<b>Item No.</b>	<b>Report of the Head of Development Management and Building Control</b>		
<b>Address:</b>	289 WEST END ROAD RUISLIP		
<b>Development:</b>	Erection of a two storey building accommodating 2no. three-bed flats with associated parking and works, involving demolition of existing dwelling (revised plans 30.05.24)		
<b>LBH Ref Nos:</b>	<b>78436/APP/2024/915</b>		
<b>Drawing Nos:</b>	3433/6D 3433/5D 3433/4D 3433/3D 3433/7D B2A B1 3433/2 3433/1		
<b>Date Plans received:</b>	16-04-24	<b>Date(s) of Amendments(s):</b>	09-04-24
			15-04-24
<b>Date Application valid</b>	16-04-24		15-04-24

The site is located on the corner of West End Road and Edwards Avenue. It is currently occupied by a brick built bungalow that is utilised as a single family three bed dwelling. The existing site benefits from two existing vehicular accesses off Edward's Avenue. Planning permission is sought for the erection of a two storey building accommodating 2no. three-bed flats with associated parking and works, involving demolition of existing dwelling.

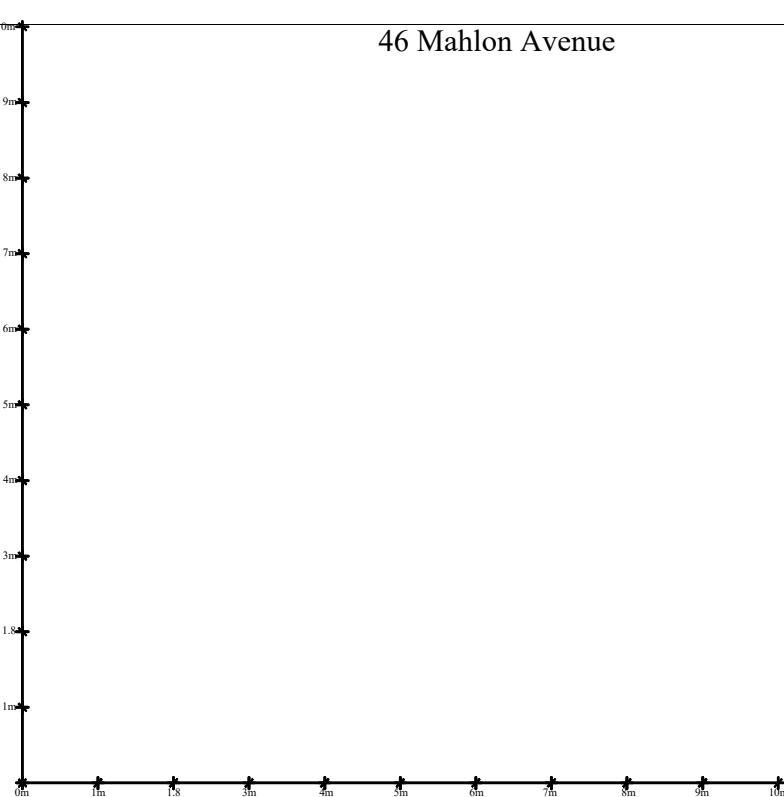
Drawing 3433/3 titled Layout Plan shows that Lamp Column 21 on Edwards Avenue would require relocation which may be problematic as Lamp Column 21 is located between the existing crossover to 46 Mahlon Avenue at the rear of the application site. The Street Lighting Engineer should be consulted.

Statement states that EVCPs would be provided, however, this has not been shown on Drawing 3433/3 titled Layout Plan. 1no. active 7Kw EVCPs should be provided for each carparking space which could be conditioned.

The applicant has submitted Drawing 3433/3C titled Layout Plan which shows the extension to the proposed vehicle crossover which would be acceptable and should be carried out under s.184 Highways Act 1980 agreement at the applicant's/ developer's expense.
